MEMORANDUM

SUBJECT: SP-17-001/ CDR-16-007 – Falcon Marketplace
Fourth Submittal

Preliminary Plan

CHECK DAM SECTION C-C (SHEET C7.1)
NO SCALE

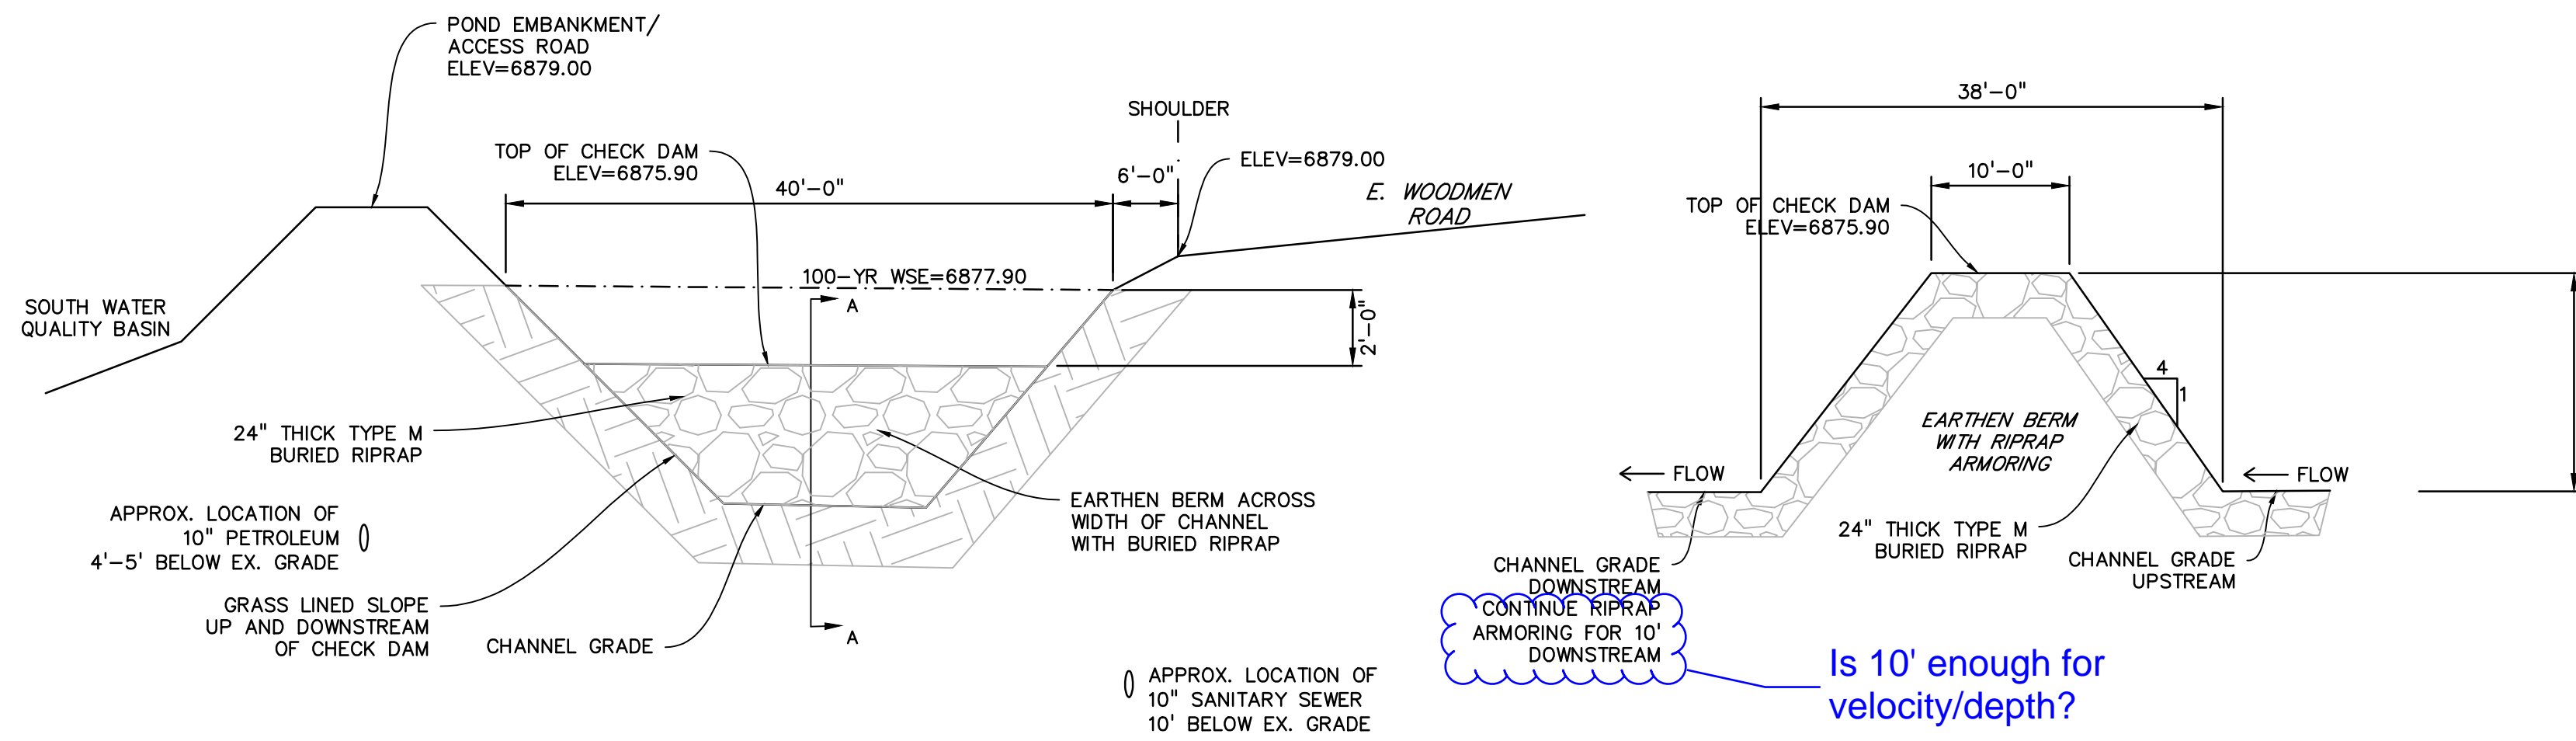
15. *Resolved*
 16. Reference attached UDFCD outlet structure design details. Specific items that need to be incorporated into the project's outlet structure designs include the orifice plate design and notes, water quality plate details (type and thickness), stainless steel well screen (page OS-9) and neoprene gasket. Complete review of sheet C7.9 will be provided after revisions. Sheets C7.11 and C7.12 will be reviewed with the subdivision CDs. *Partially resolved; see redline regarding specific calculations for trash rack (now sheet C7.5).* **Partially resolved; see updated redlines.**

**SUB-REGIONAL POND #1 (SR4)**

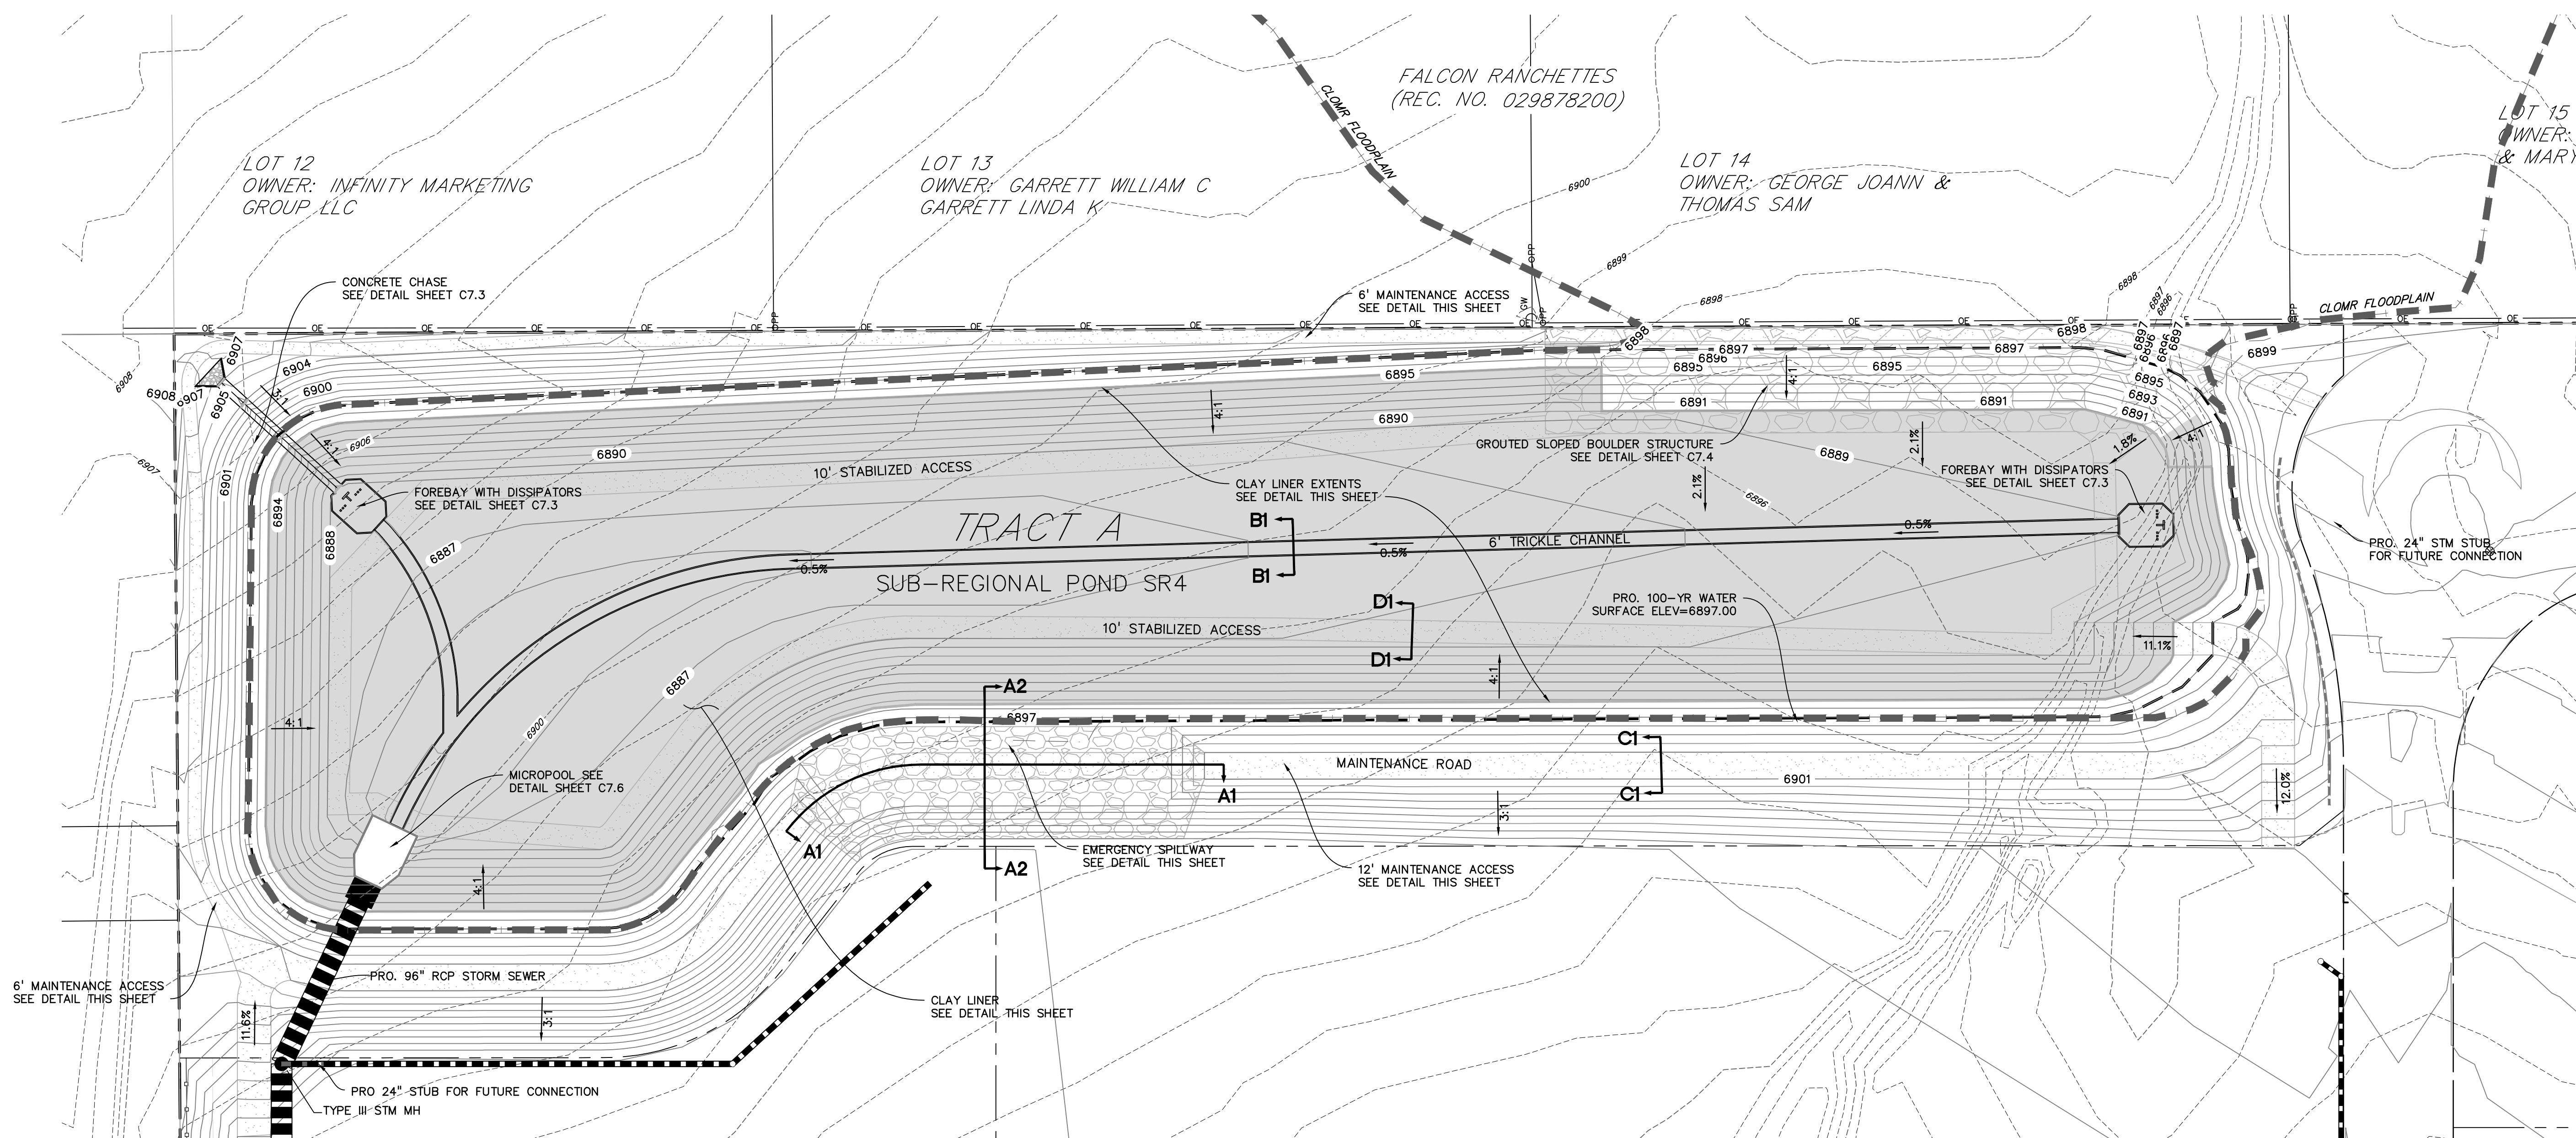
12. Resolved
13. Drainage Plan:
- a. **Resolved.**
 - b. Show and label all proposed maintenance access roads and easements on the Developed Conditions Plan. Partially resolved; see GEC redlines regarding this. Provide stabilized access roads along the west and north sides of the pond. See *additional redlines; due to the rundown along the north side of the pond, pond bottom stabilization is required which could be incorporated into an access road design through that area.* **Comment remains. Partially resolved; details need to be provided in CDs.**
